TOWN AND COUNTRY PLANNING ACT 1990

FULL

Reference: H09-0627-25 **Date of Decision:** 28th August 2025
Applicant: Mr H Juniper
28 Balmoral Way
Holbeach
Spalding
Lincolnshire
PE12 7RP
Location: 28 Balmoral Way Holbeach Spalding
Description: Proposed extension to dwelling to form bedroom and en suite above former garage

Drawing Number:	A1787- 11	Rev:	P1
-----------------	------------------	------	-----------

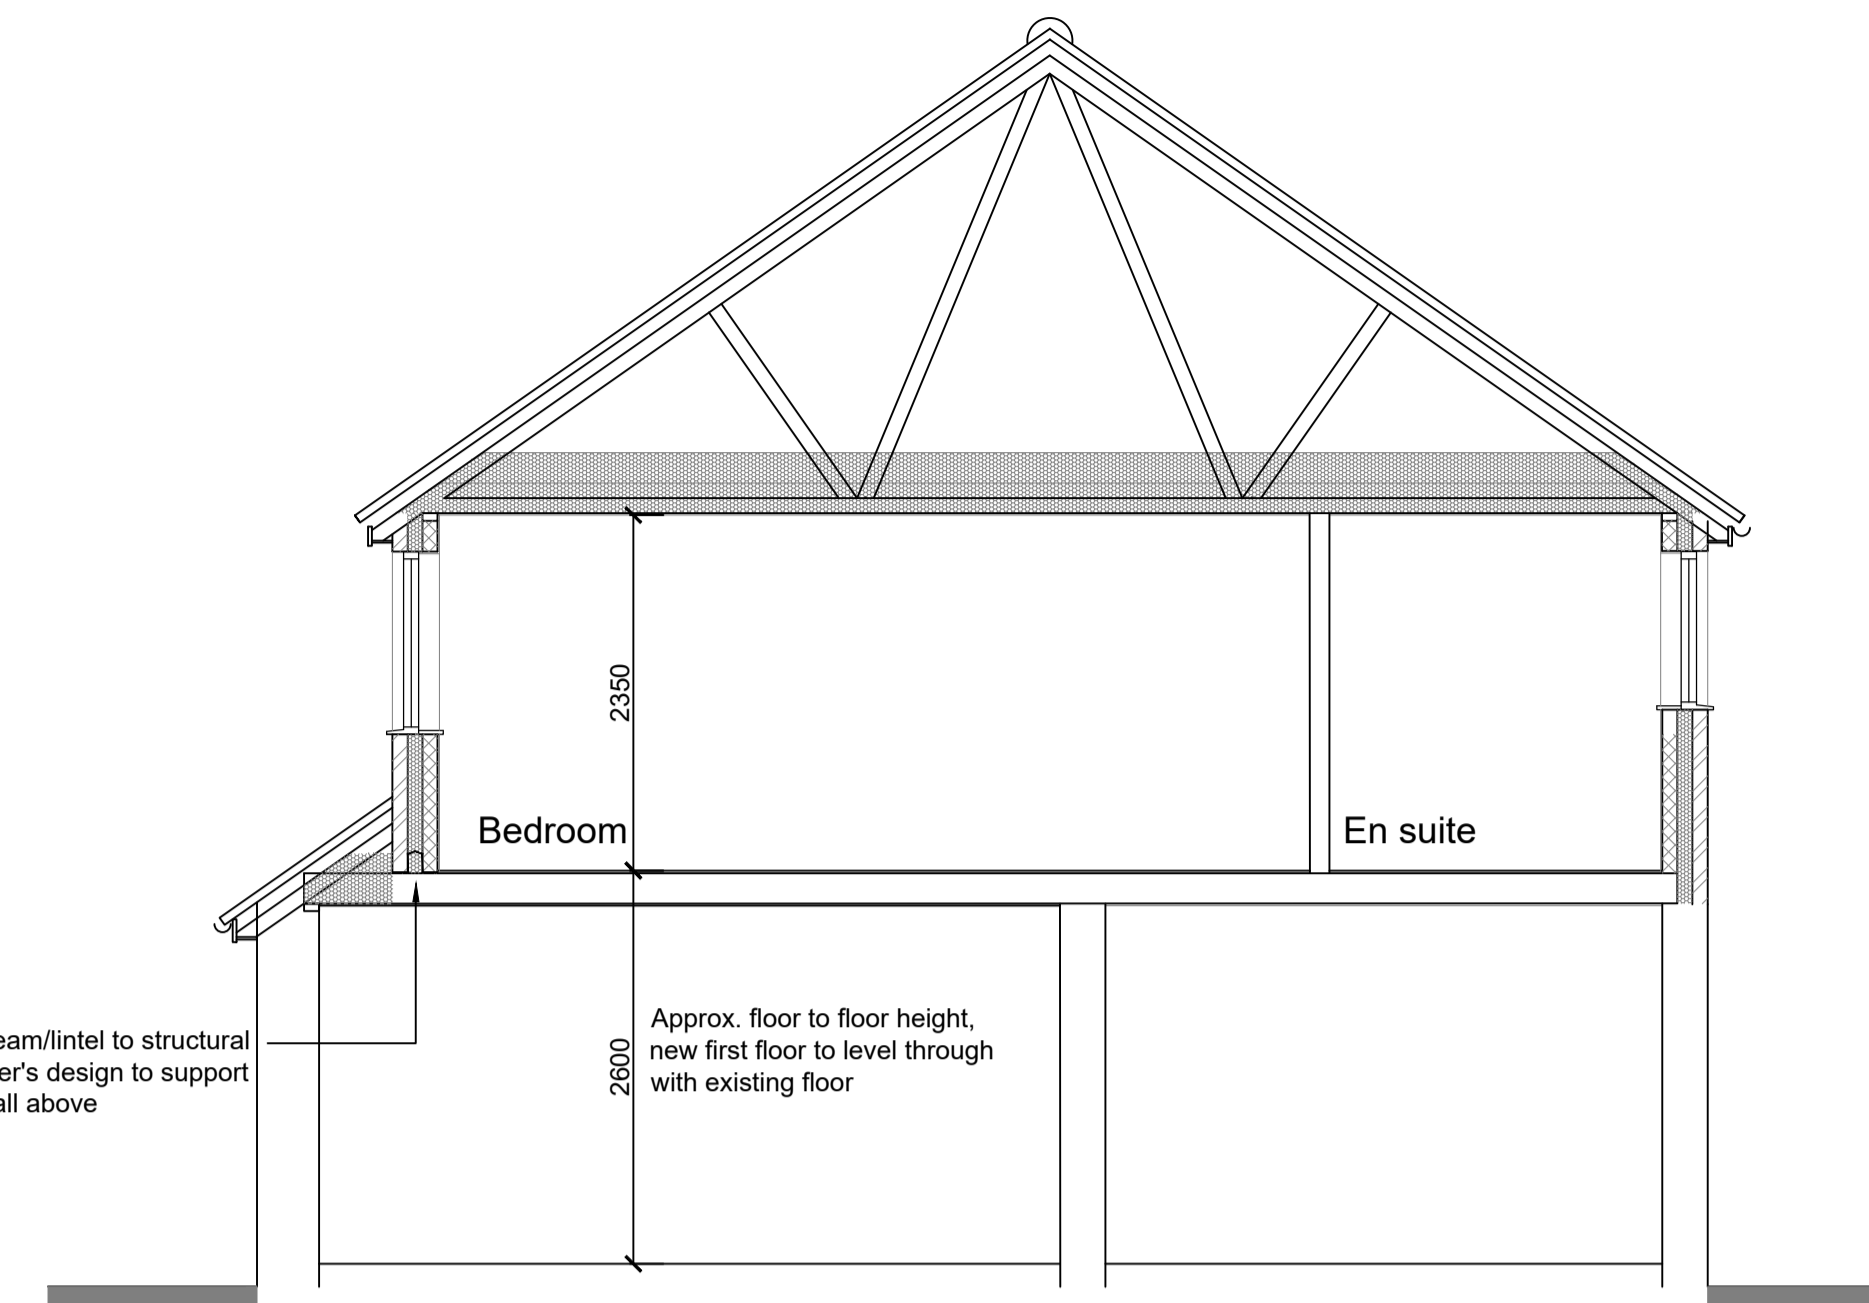
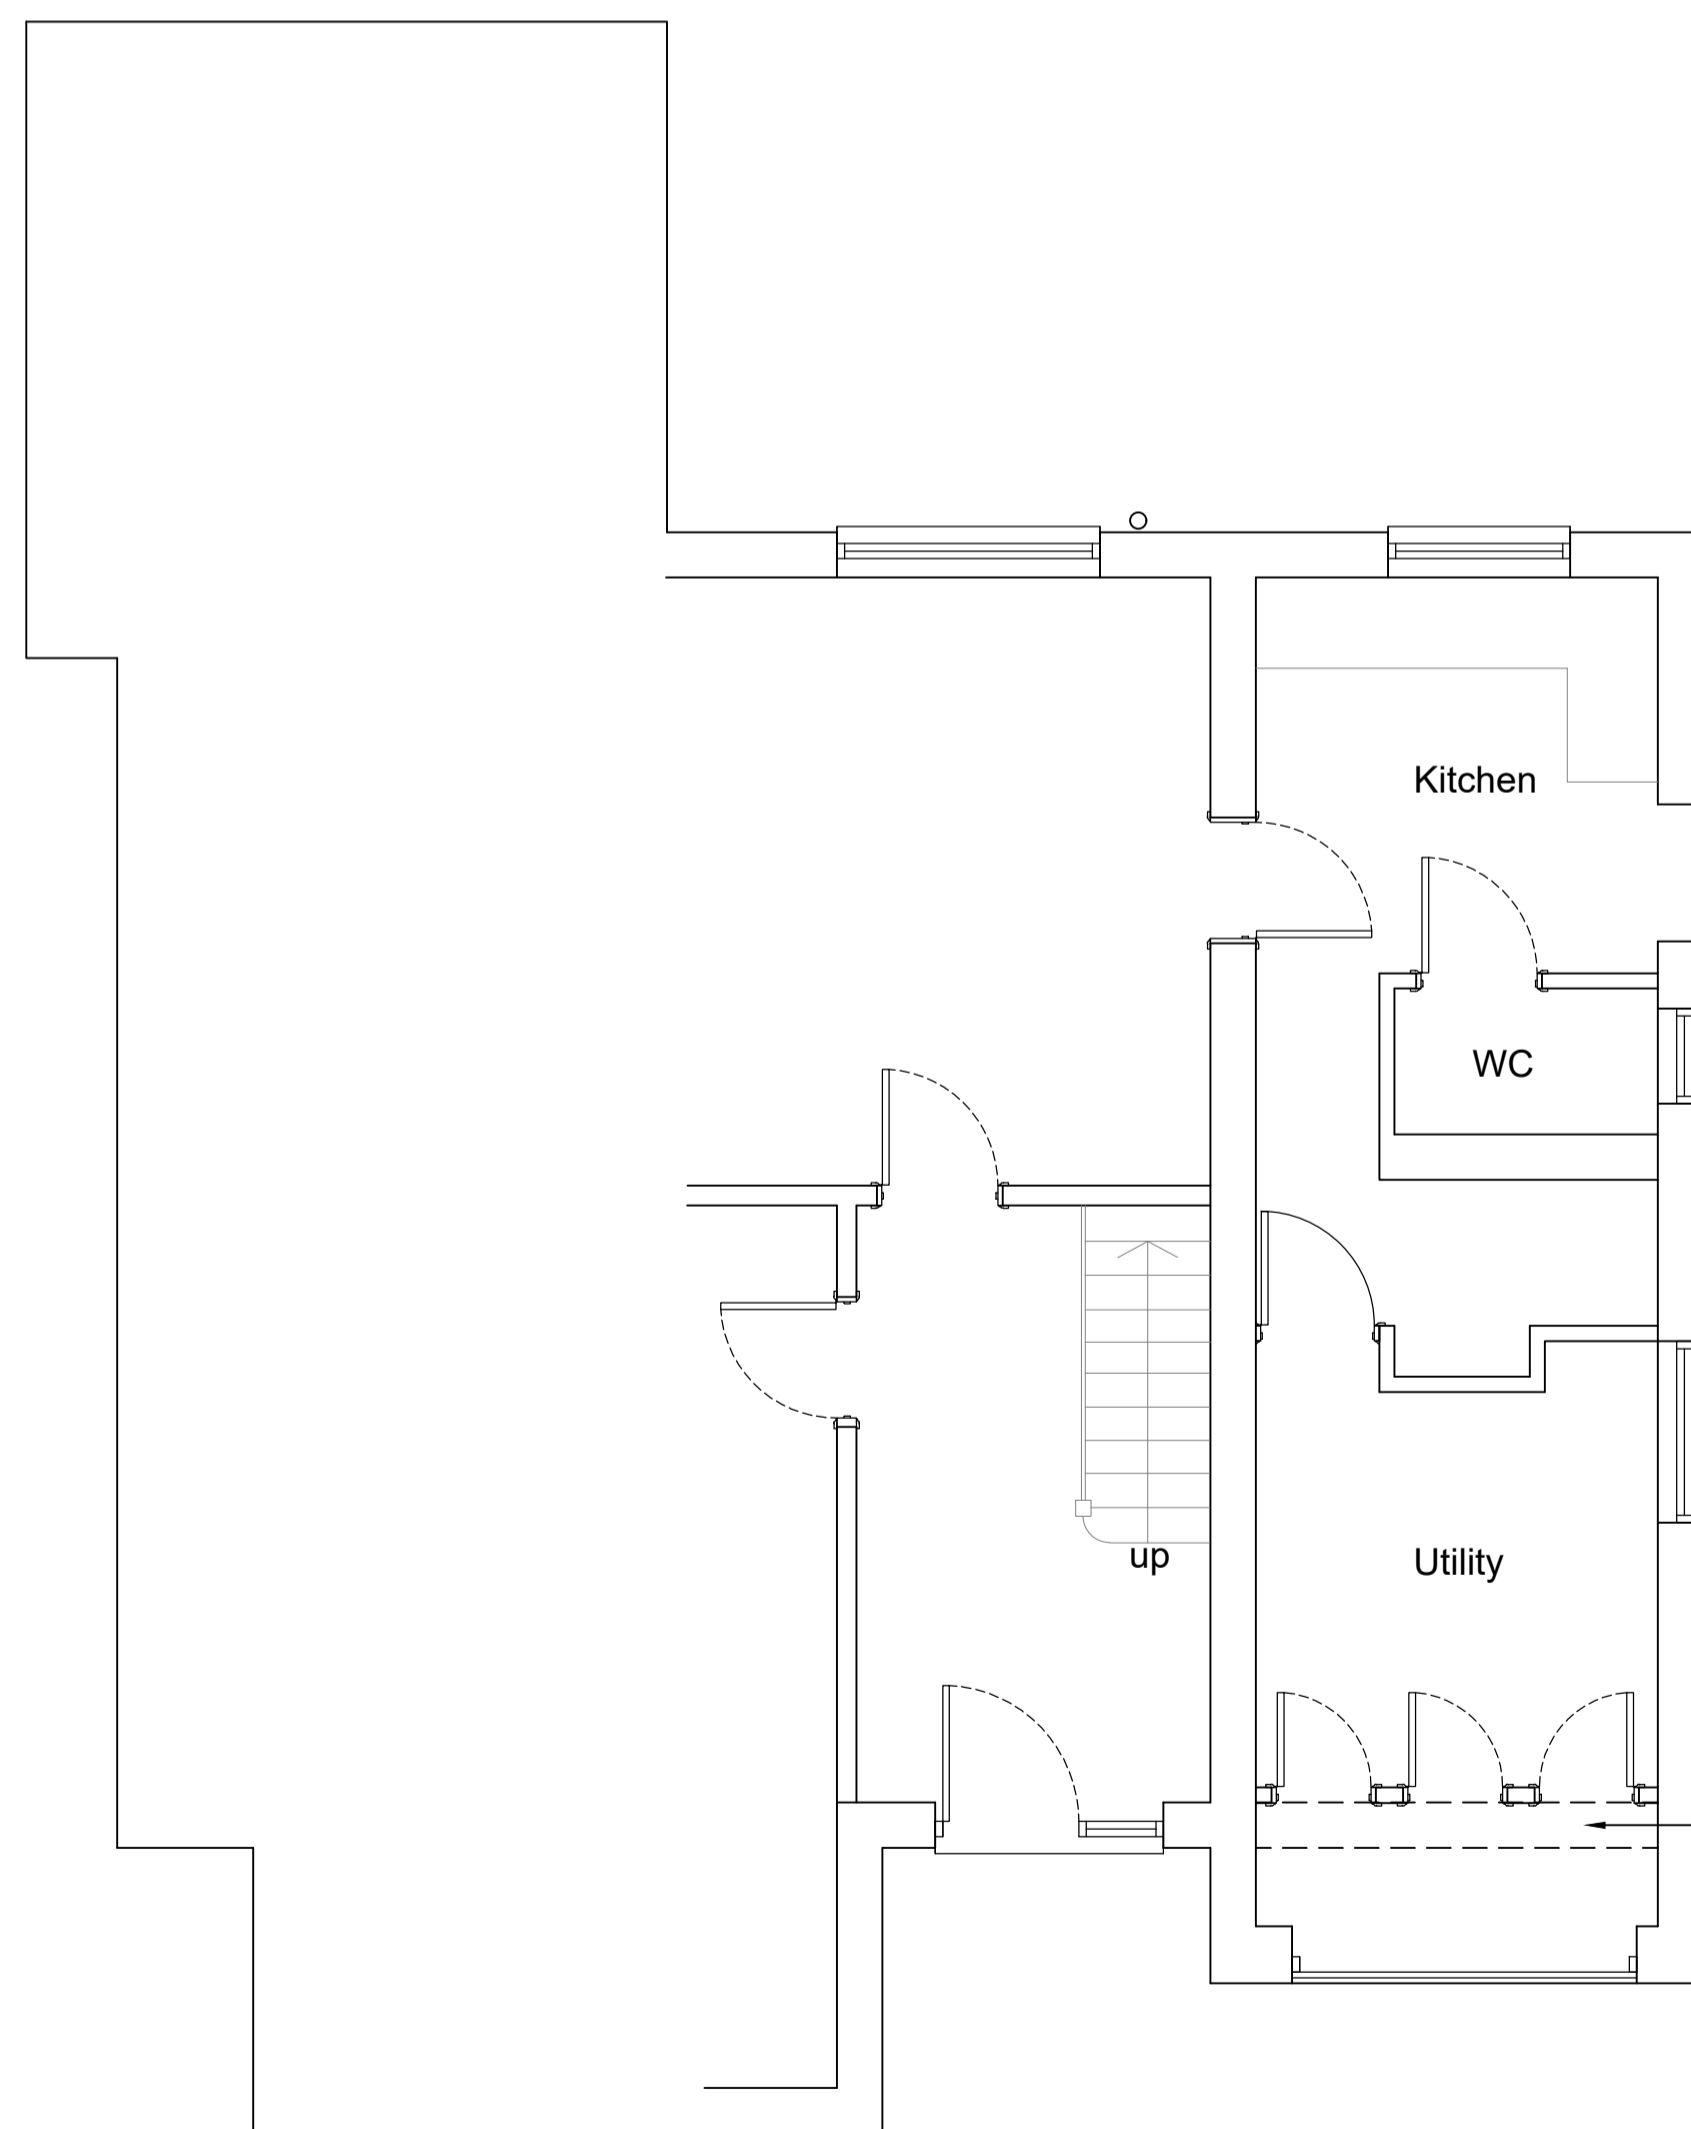
- 4 Notwithstanding the details submitted, before any part of the development hereby permitted is occupied, the following window(s) shall be installed with obscure glazing (to a minimum level of Pilkington - Privacy Level 3 or an equivalent product) and shall have no opening part being less than 1.7m above the floor level immediately below the centre of the opening part.

- Rear en-suite window

Once installed, the window shall thereafter be retained as such.
